Your Ref: OWPC26213
Our Ref: AB/20/20/CLP 09-03-2020
Please ask for:
Zac Denton

Lawful development certificate for a proposed extension to existing track across the field to meet The Causeway at the entrance to the field.

Land to the rear of Queens Lane Arundel

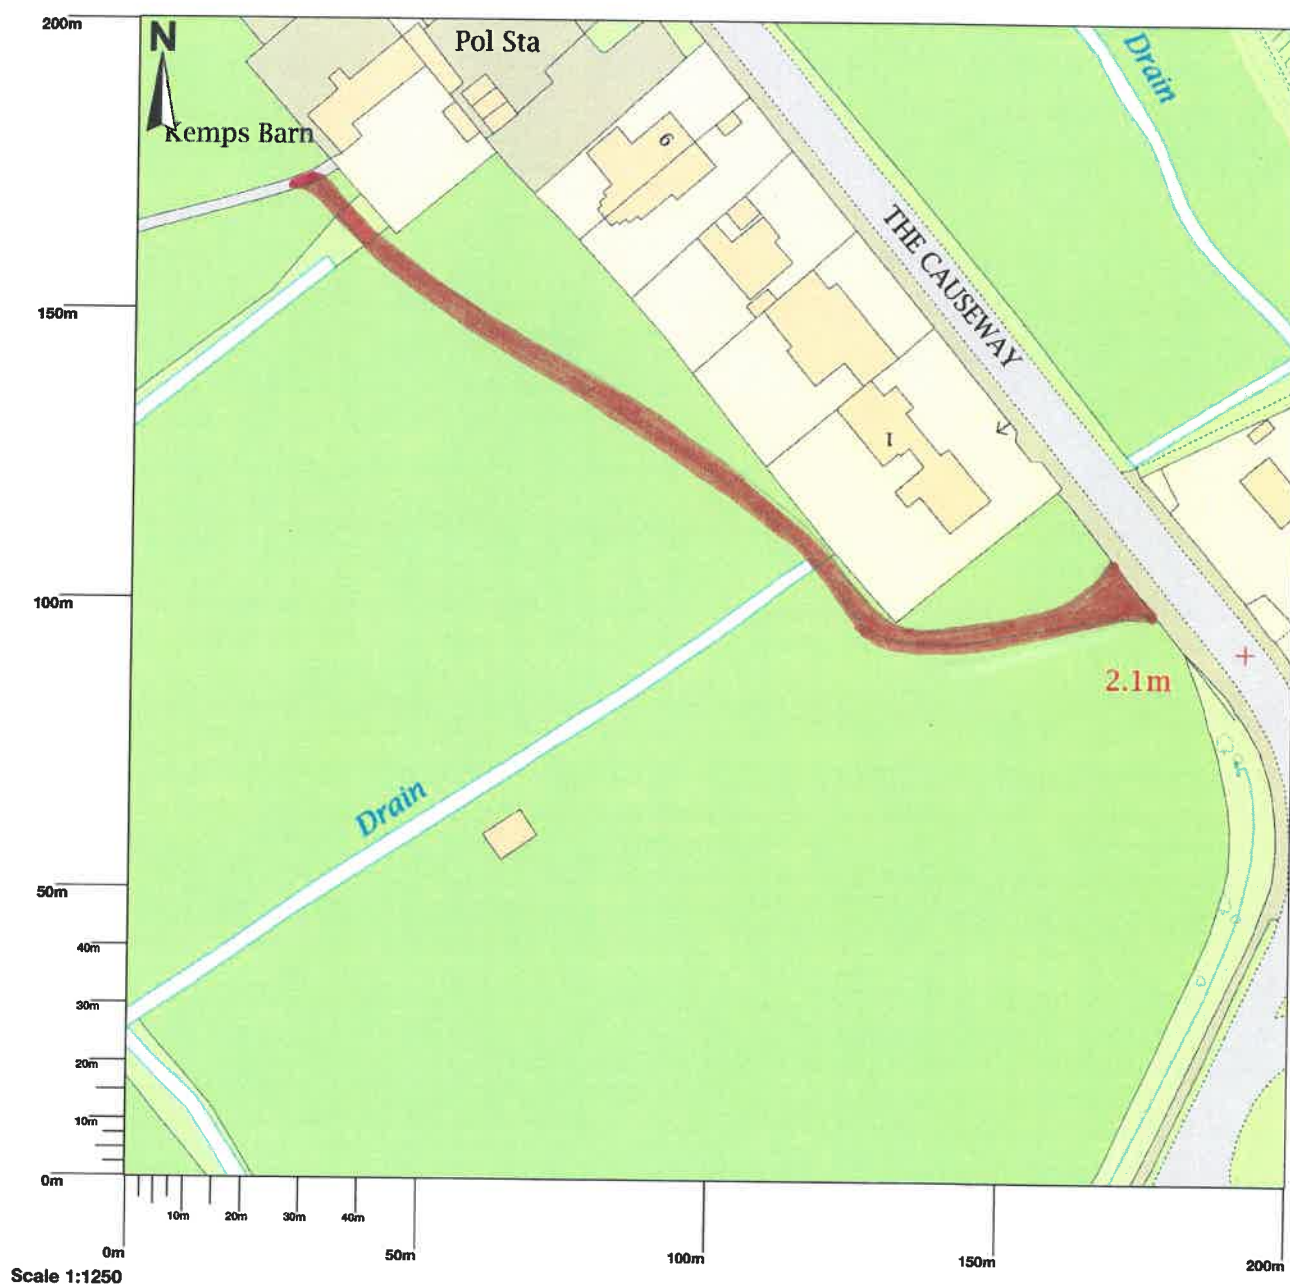
The Committee have no objection to the new access it would seem sensible but can they not take the route away from the back of The Causeway houses?

It looks particularly close to the back of number 1 The Causeway. They haven't done this because there is a ditch through the middle of the field but it would only take a concrete culvert/pipe and a bit of fill to bridge it. A small cost to provide a more neighbourly solution - the Committee request this as a condition.
